Your ref:	FOOTMAN - Mayfair -161119	Please reply to:	Phoebe Graham
Our ref:	21/03825/ADV	Tel No:	07971 024216
		Fee Queries:	0207 641 6500;
		Email:	planningreception@westminster.gov.uk;
Mrs Gillian Shepley Ashleigh Signs Ashleigh House Beckbridge Road Normanton WF6 1TE England		<b>Incomplete Applications</b> Development Planning City of Westminster PO Box 732 Redhill, RH1 9FL	
		14 June 2021

**Address: Running Footman , 5 Charles Street, London, W1J 5DF**

**Proposal: Display of one non-illuminated fascia sign measuring 195mm x 1820mm, one externally illuminated hanging sign at first floor measuring 750mm x 900mm, two non-illuminated awnings measuring 200mm x 1400mm and 200mm x 3400mm, one internally illuminated menu box measuring 500mm x 377mm and one non-illuminated flag at first floor measuring 1800mm x 900mm.**

ITEM 01 (Qty 1)

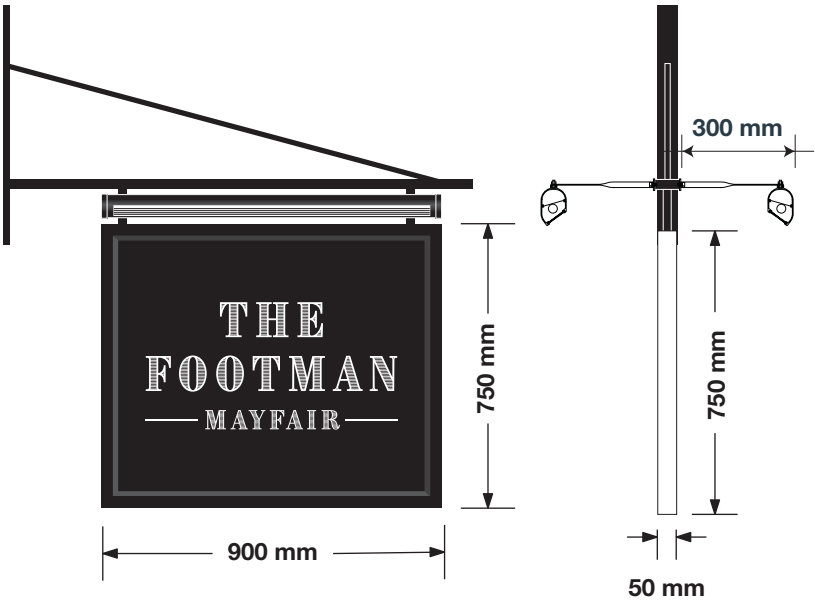
- sections through the hanging sign and the menu box which show the method of illuminated (external and internal)
